**KIRKLEES METROPOLITAN COUNCIL
INVESTMENT & REGENERATION SERVICE**

DELEGATED DECISION TO DETERMINE PLANNING APPLICATIONS

Reference No:	2023/62/92059/W
Site Address:	23, Dirker Bank Road, Marsden, Huddersfield, HD7 6AR
Description:	Erection of detached building to create dwelling forming annex accommodation associated with 23, Dirker Bank Road, Marsden, Huddersfield, HD7 6AR
Recommending Officer:	Lucy Taylor

Officer Report.

DWG TITLE: **Elevations Proposed** DWG No: **A.02.4** STATUS: **PLANNING** Rev: DATE: **05/07/2023** SCALE @ A3: **1:50**

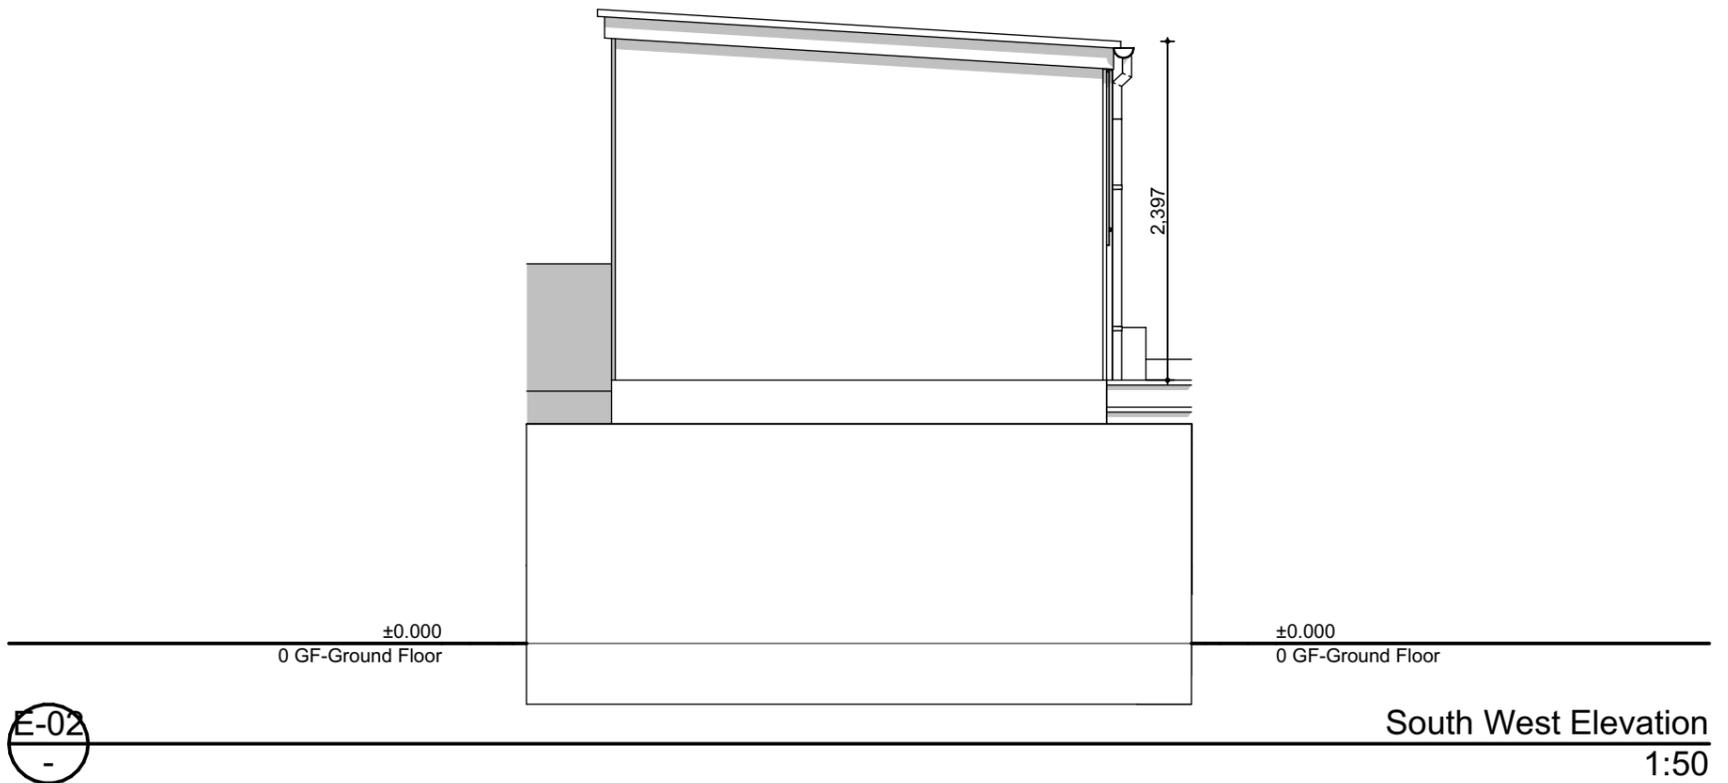
The blank side elevation of the proposed outbuilding, facing towards the rear amenity spaces of the neighbouring terrace properties, would further increase the extent to which it would be read as imposing visually. Introducing a new blank, solid elevation of a significant size/scale.

It is considered that the proposed annex building and raised decking would result in undue levels of overlooking to the rear amenity spaces of these neighbouring properties, with the only form of boundary treatment erected low wooden fencing. In addition, it is considered that the annex building and raised decking would overlook the property of No. 21 Dirker Bank Road, especially with regard to the glazing which is considered to serve habitable rooms to the rear elevation of this neighbouring property.

In addition, the proposed annex building would pose an overbearing effect to No. 21 Dirker Bank Road, separated from the shared boundary by only approximately 0.6 metres and from the rear elevation of the property by approximately 8 metres. This separation, together with the 3.1-metre-high solid side elevation, would pose an overbearing effect. It should be noted that the proposed annex would be considerably higher than the boundary treatment between No. 21 and 23, which comprises of low wooden fencing.

1. The proposed development and associated works, by virtue of their scale, massing and siting, would not appear subservient to the host property and would be overly prominent and incongruous additions within the curtilage of the site to the detriment of visual amenity and character of the area, failing to comply with Policy LP24a of the Kirklees Local Plan and Policies within Chapter 12 of the National Planning Policy Framework.

1. The proposed annex building and raised decking would result in a loss of amenity arising from an overbearing and overlooking impact upon neighbouring properties, in particular No.'s 19 and 21 Dirker Bank Road, by reason of their scale, design, siting and proximity to neighbouring land and property. The development would therefore not be compliant with the aims of Policy LP24b of the Kirklees Local Plan or Policies within Chapter 12 of the National Planning Policy Framework.
